Consultation Response from KC, Highways Development Management
2023/93704 land northwest of, Urban Terrace, Denby Lane, Grange Moor, Huddersfield, WF4 4EB
Erection of 10 dwellings and associated works
Date Responded: 18/07/2024 Responding Officer: Ryan Kinder Responding Ref:K16-6/38
2023/93704 land northwest of, Urban Terrace, Denby Lane, Grange Moor RECOMMENDATION: Objection due to: - refuse storage and collection being substandard. - Internal layout not to adoptable standard. Development Overview: The site takes access off Denby Lane in the village of Grange Moor, the site is located between the junctions of Stoneroyd and Denby Park Drive. Reference plans/documents: - Site Layout – ref 22D26-FBA-ZZ-XX-DR-A-0708-P11 dated Oct 2023 - Long sections – ref Y22054-D901=REV1 dated 20-11-20223 - Transport Statement – ref 23102-1 dated Nov 2023 - Revised site layout - ref 22D26-FBA-ZZ-XX-DR-A-0708-P17 dated Oct 2023 Updated comments 18/07/2024 Further to submission of revised site layout, an additional 2.0m wide footway has been provided adjacent to plot no 3 which is a welcome improvement. The refuse collection arrangements remain unchanged to the previous layout, the drag distance for r

1 Proposed Site Layout

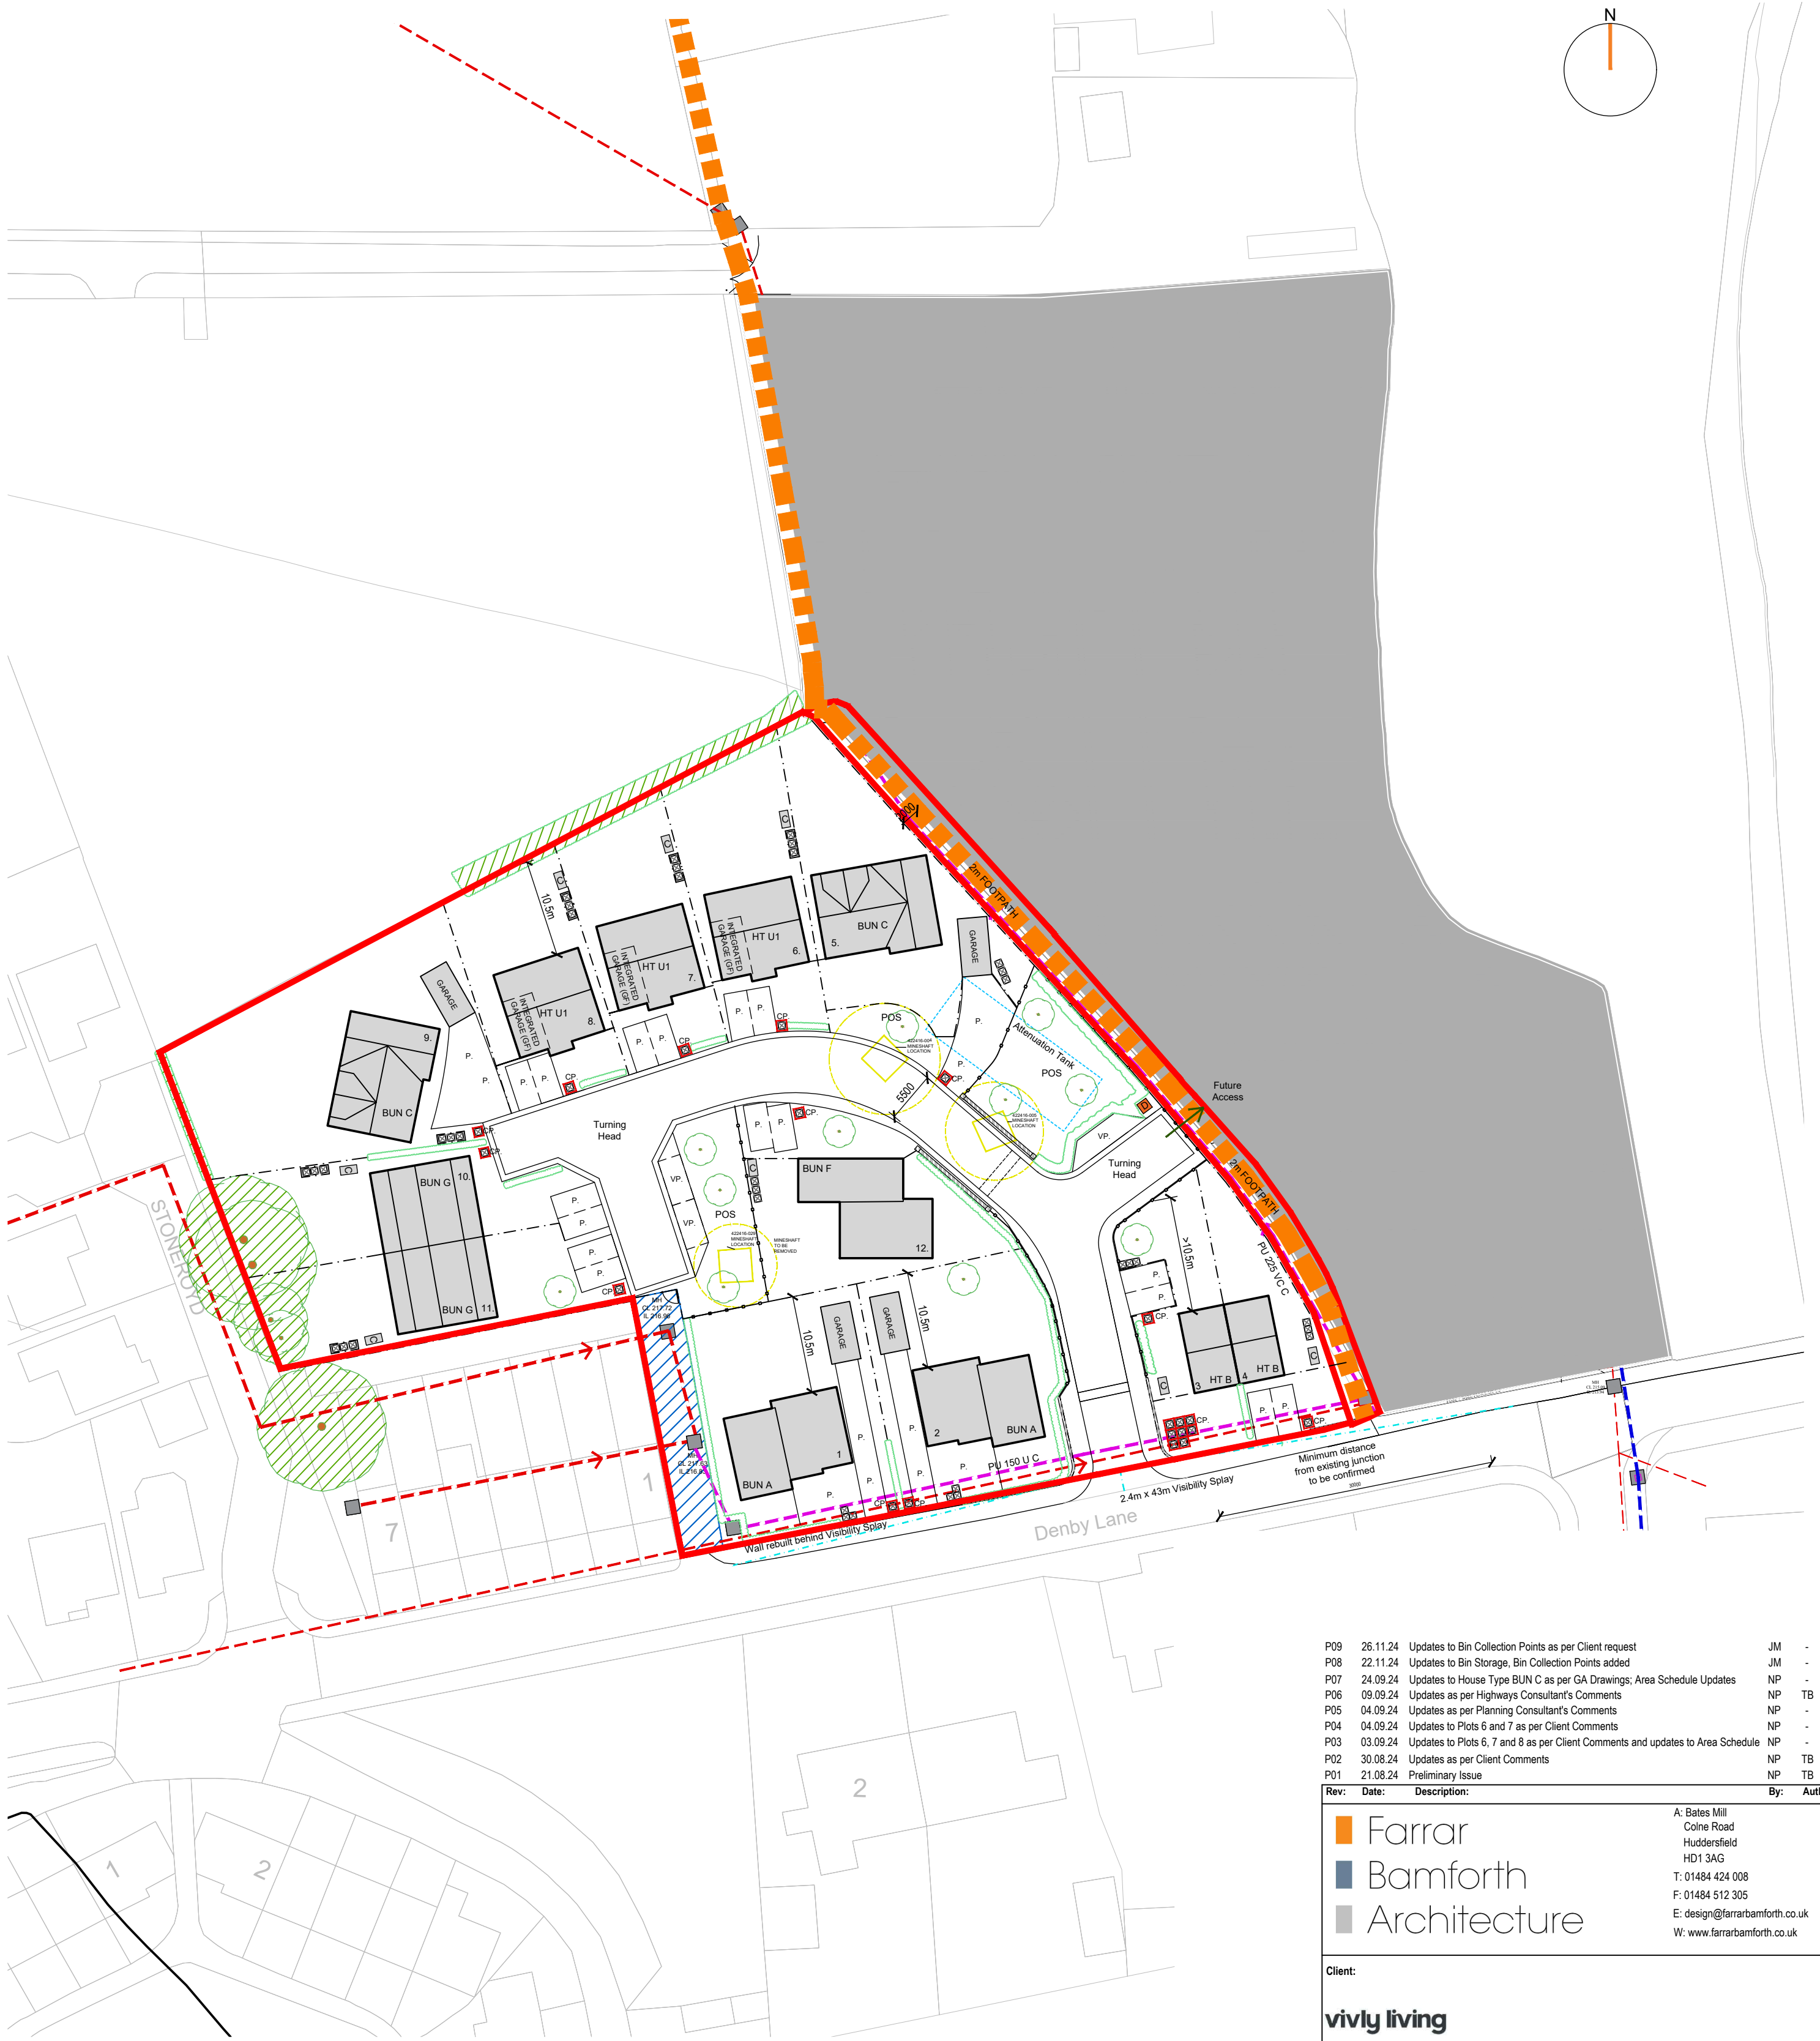
The applicant has advised that the internal layout will remain private, however this should still be built to adoptable standards, it is considered that the initial section of road up to the gated arrangements and round to the area marked for 'future development' should have 2.0m wide footways on each side and be of traditional estate road arrangement.

No information has been provided in terms of refuse collection, the current indicated refuse collection point for plots 4 to 10 is in excess of the adopted highway and therefore unacceptable, it is suggested that the initial section of road be adopted and suitable swept paths demonstrated for a refuse collection vehicle. Or a bin collection point located adjacent to Denby Lane to serve the development as a whole. The bin collection point for plots 5- 9 is also in excess of the adopted highway and considered unacceptable.

The gating off of the private road raised concerns for emergency service vehicles, it is recommended this element be removed.

It appears an acceptable level of off street parking is provided for each dwelling, confirmation of parking space sizes for each dwelling and garage sizes is requested.
